ADDENDUM TO SUPPORTING STATEMENT

To previously approved application for Demolition of existing rear projection and construction of a single storey rear extension with a flat roof, 3 panel sliding door and 3 roof lights with other associated alterations.

**72 EARLSHALL ROAD
ELTHAM,
SE9 1PR**

Ref: 1448/E

Dwg. No.  
**1448-30**

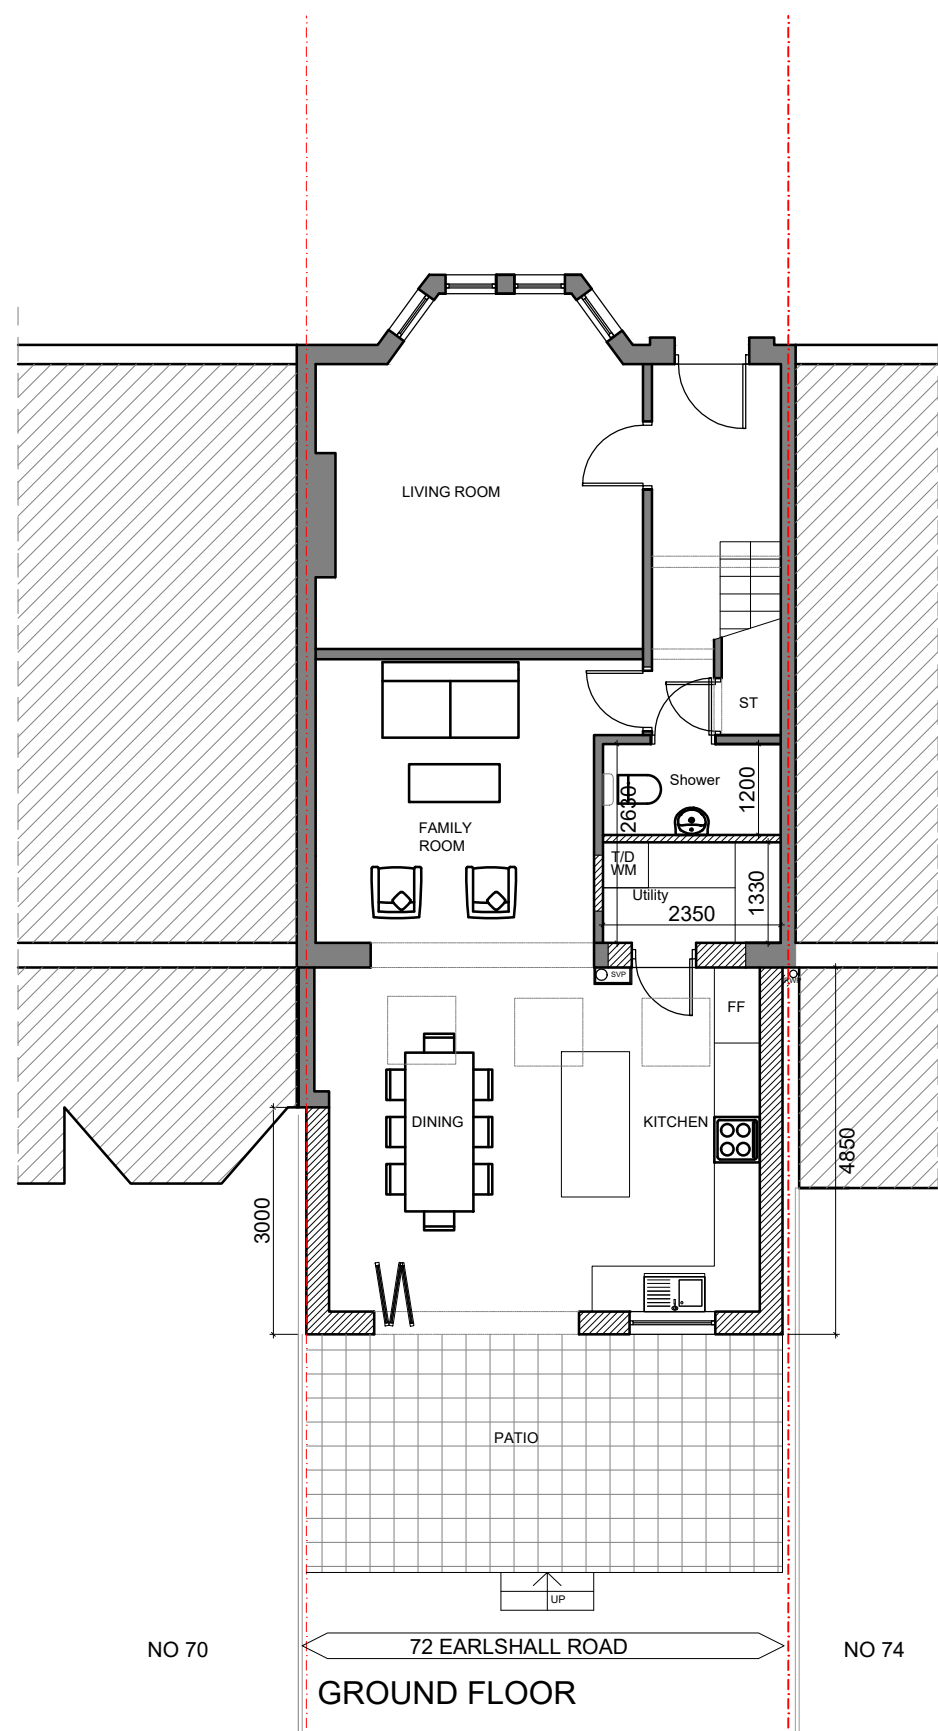
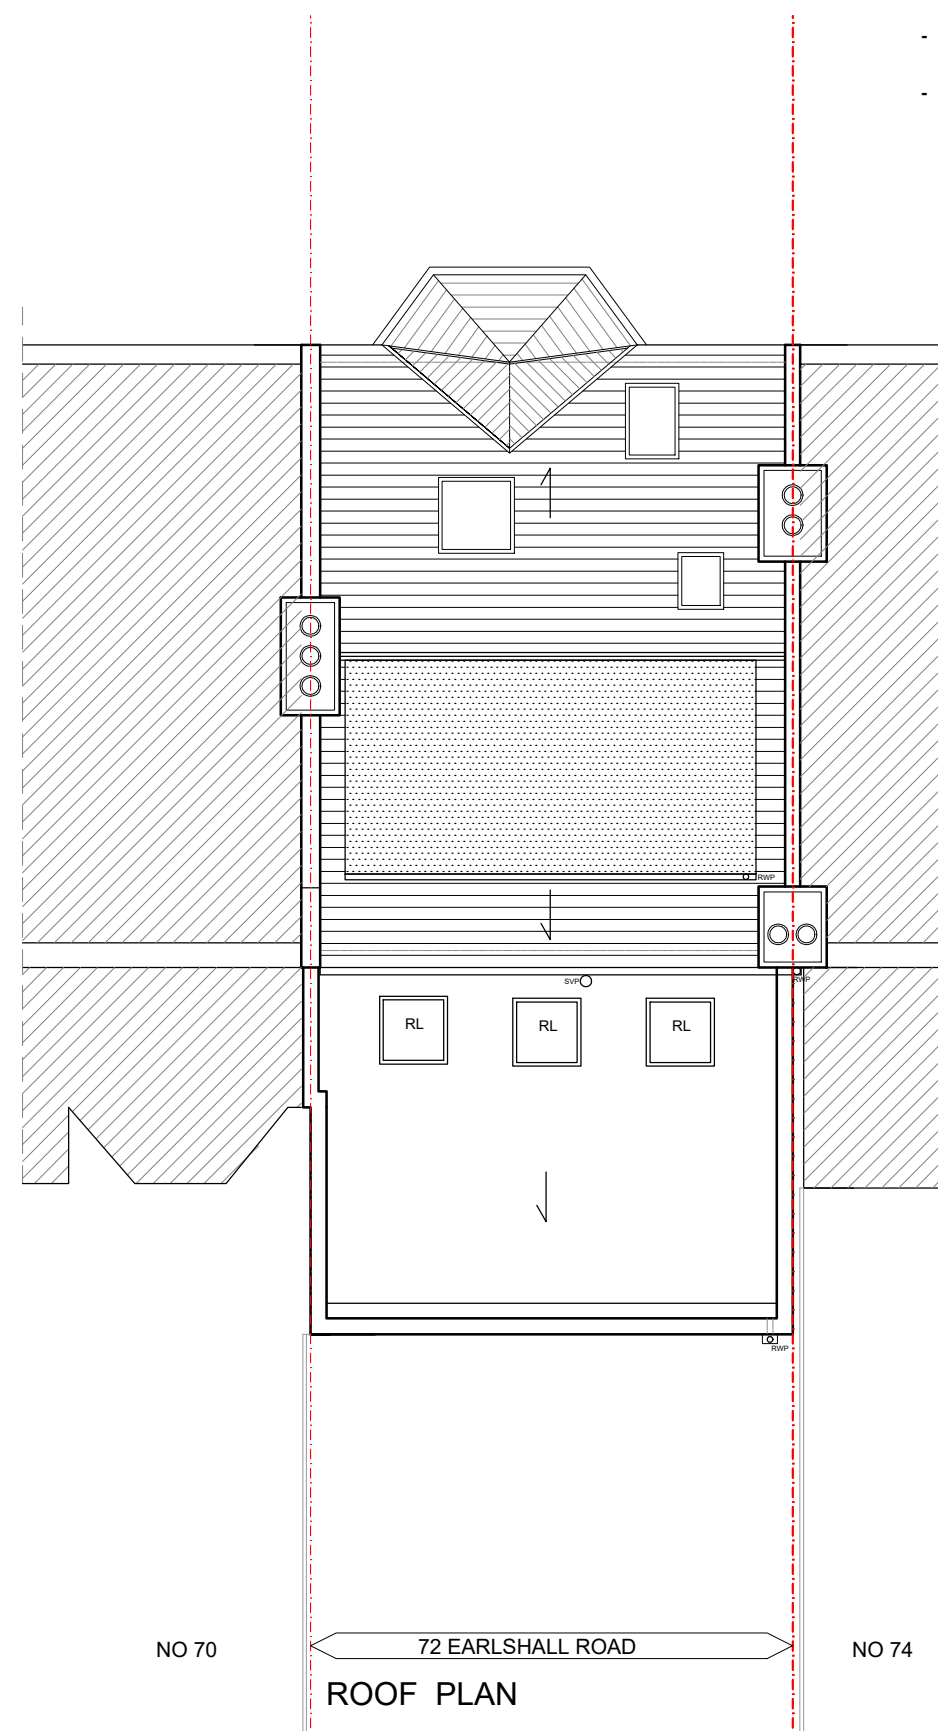
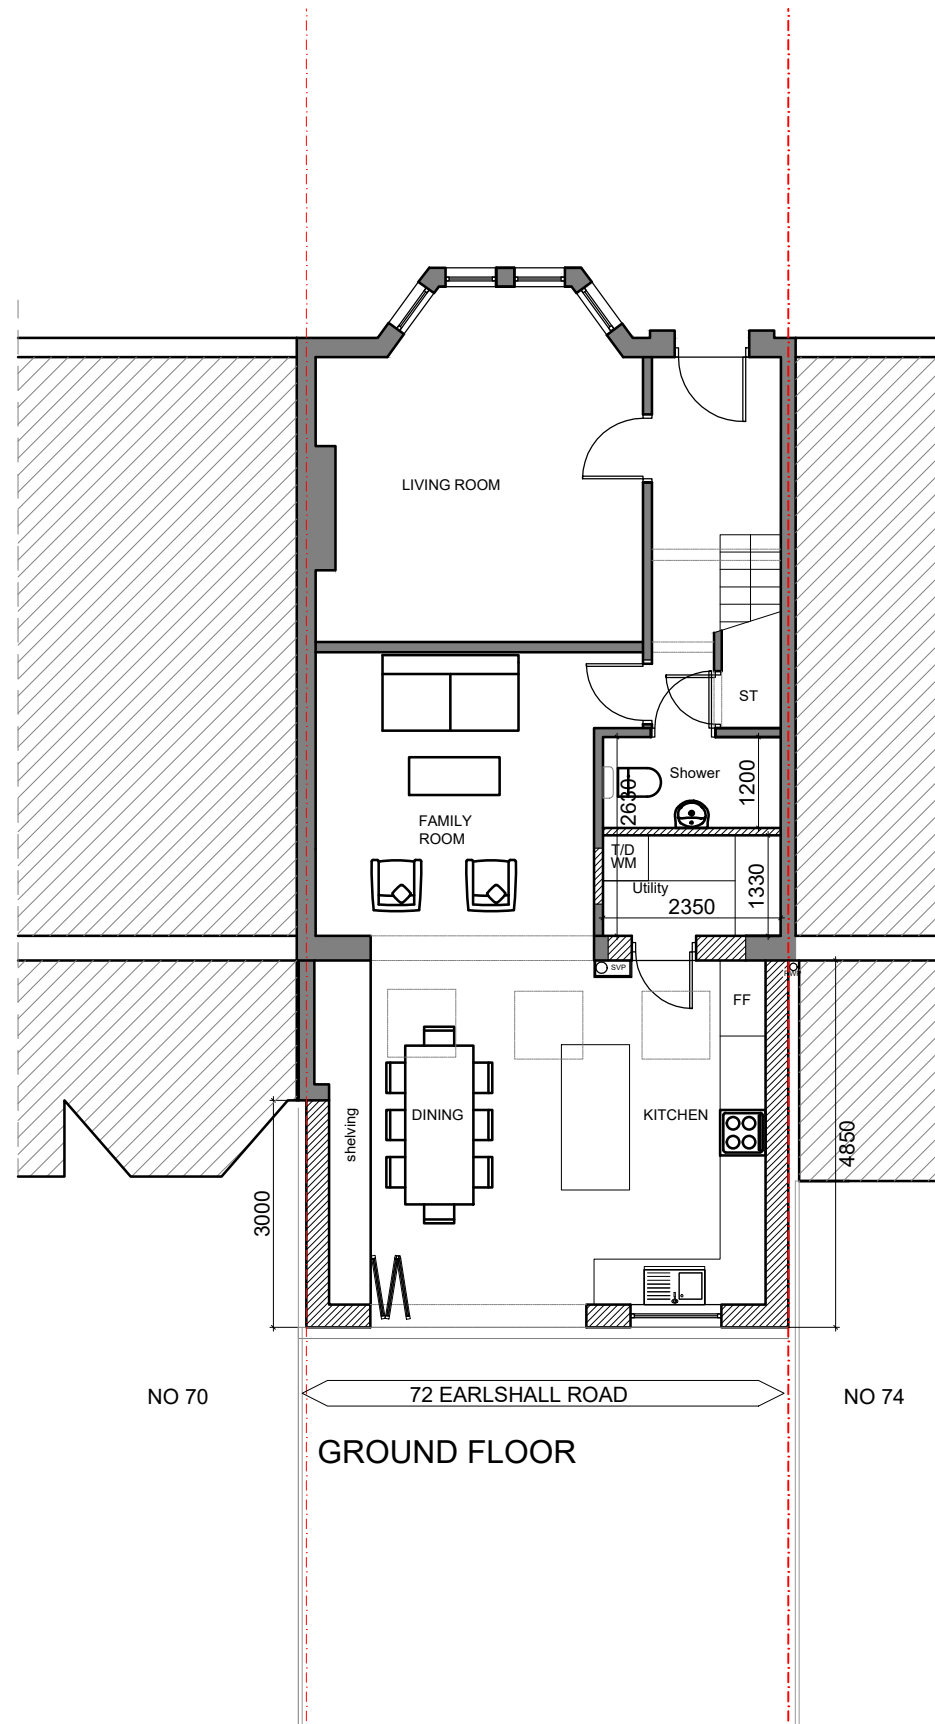
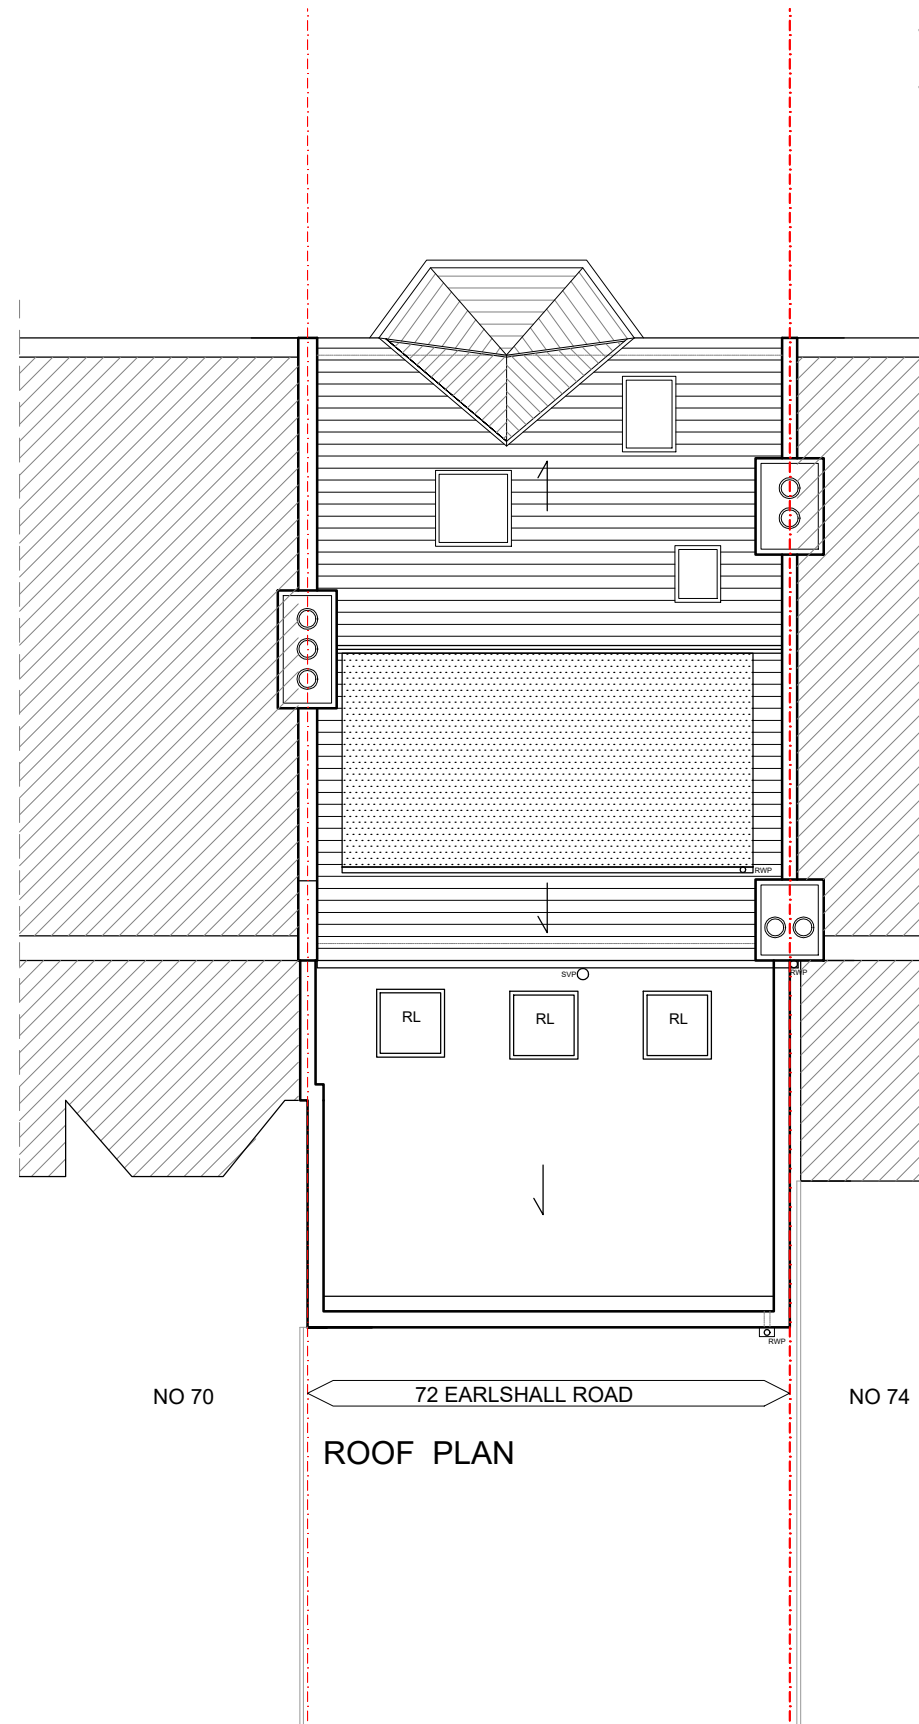
On the original planning drawing, no new patio was shown as there was an extensive existing patio, and it had not been anticipated that the patio would exceed 0.3m in height, above ground level, and as such consent was not required. At Building Regulations stage a patio of 2m depth was added and this was shown with a step down of 150mm from finished ground floor level, which did not require planning consent. When on site it was decided to retain the patio at ground floor level to retain a level access as preferred by part M of the Building Regulations and to improve access generally. In addition it was decided to extend the depth of the patio to 3m. None of this in itself requires planning consent, however the ground falls away from the rear of the house, and as a result at the furthest extent of the patio there is lower level. This difference was further increased as the area directly in front of the patio has been levelled out a little directly in front of the patio i.e. reduced in height. Overall this gives a step down of approx. 450mm, which is just 150mm above that allowed under permitted development.

The raised patio is built at the level of the internal finished floor to improve accessibility and give a better flow, and a better connection between inside and outside space. Although this is no more than 300mm at the end of the extension, because of the ground gradient which has a gradual drop towards the rear garden, at the end of the patio there is approx. 450mm from the external ground level.

1448-31

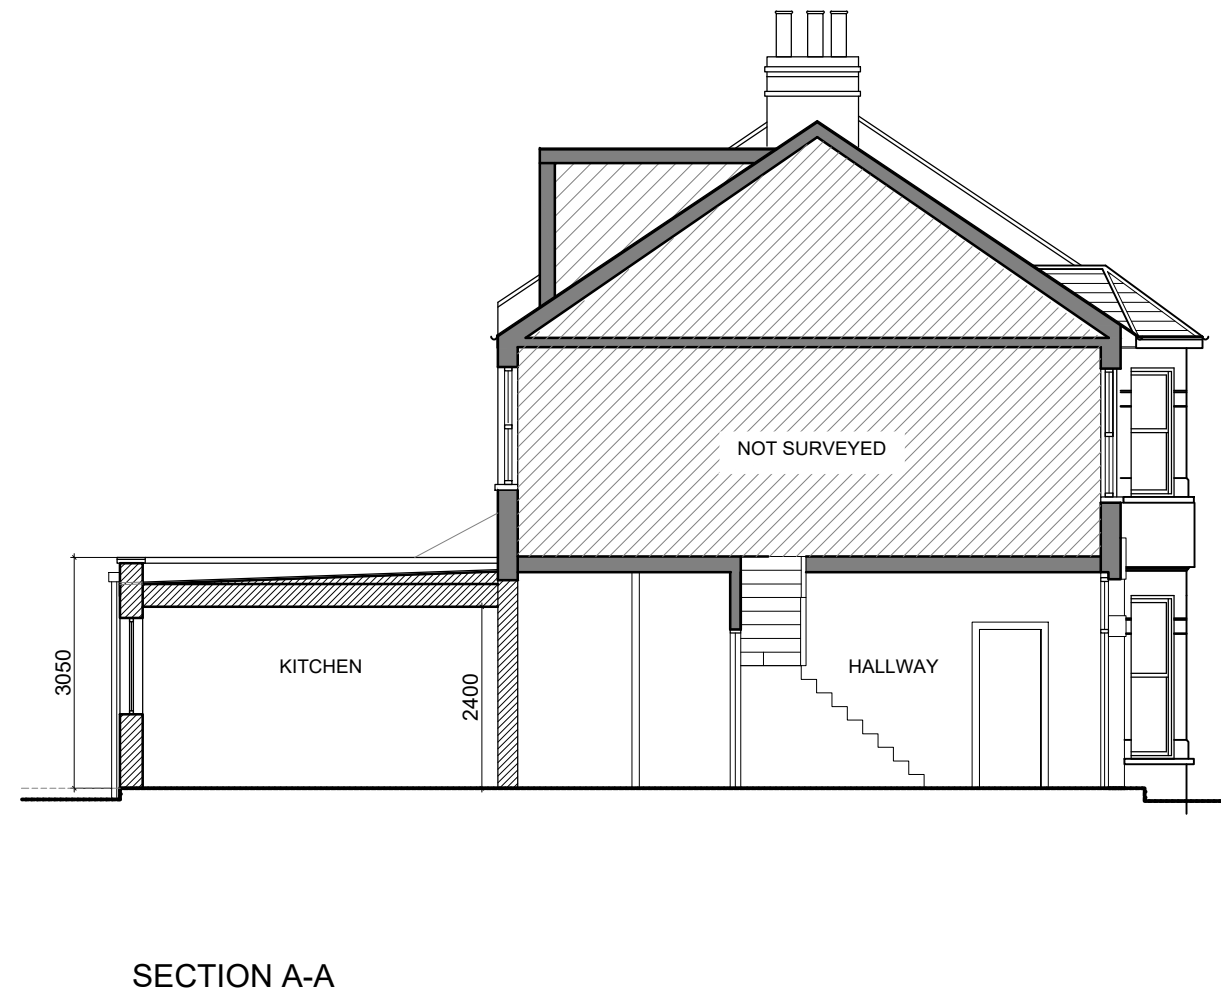
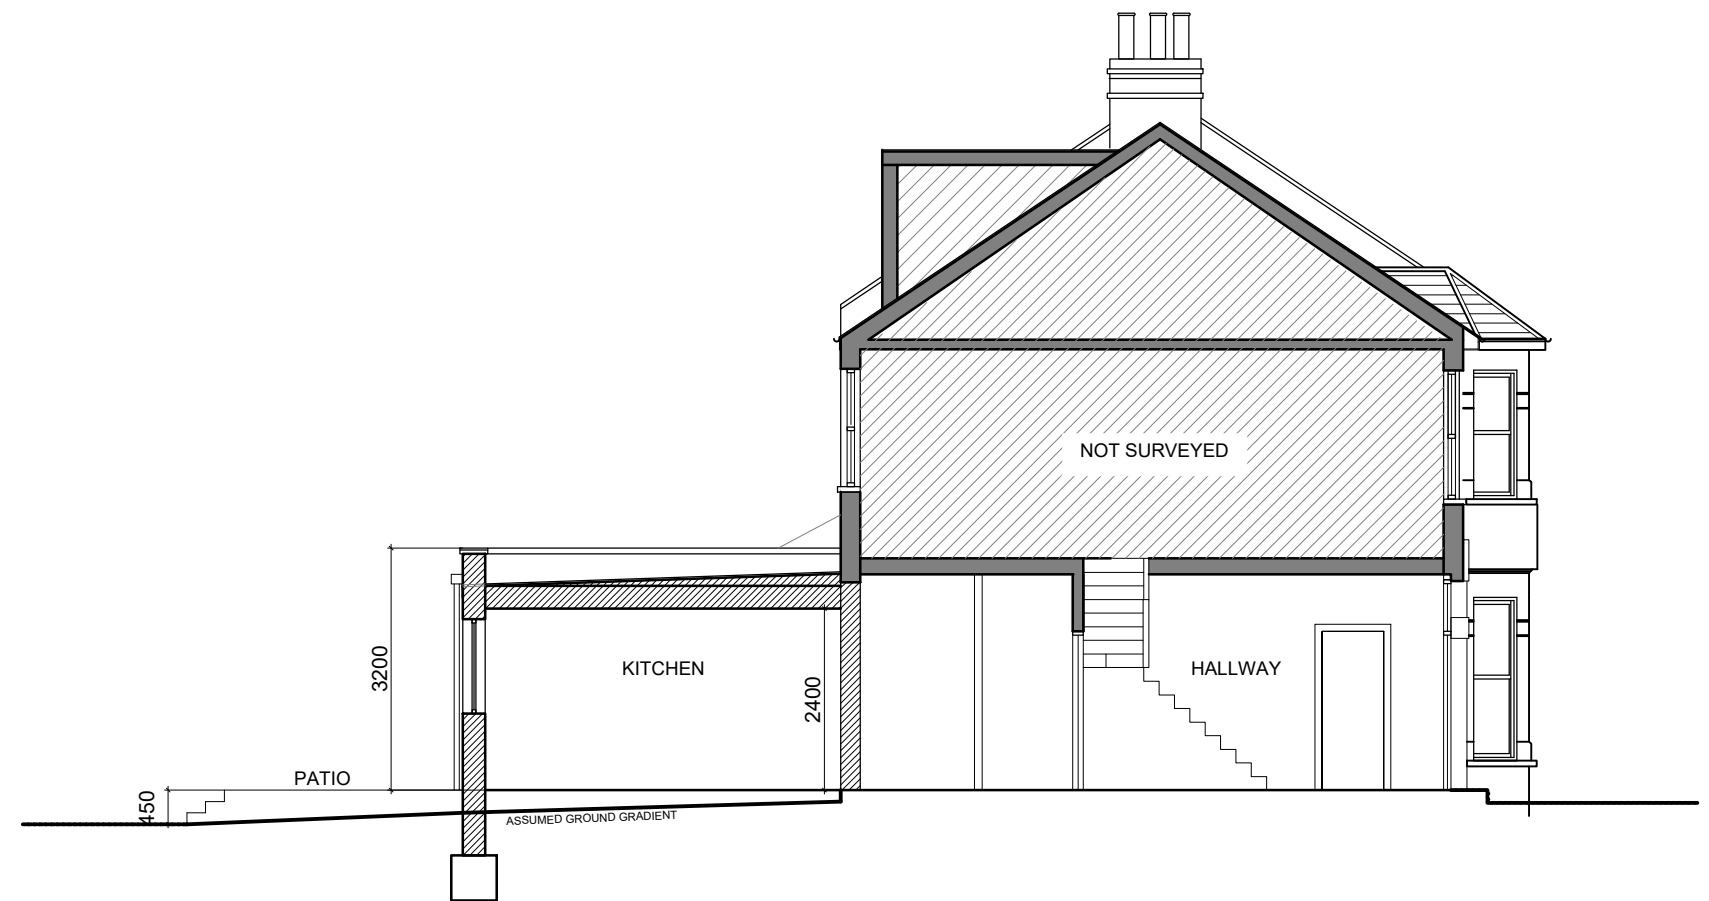
After the original planning consent and Building Regulations submission, it was necessary to increase the thermal insulation to comply with the latest Building Regulations. This increased the roof thickness and in order to retain the internal floor to ceiling height and correct flashing detail the parapet upstand could not be reduced, so overall the height of the rear extension is accordingly increased in height by 150mm to the approved plans.

The approved height was 3,050mm from ground floor finished floor level, and as shown on the attached as-built drawings it is 3,200mm. This is an increase of just 5%. We believe this increase in the height is minimal and is within the normally acceptable percentage increase for alterations on site.
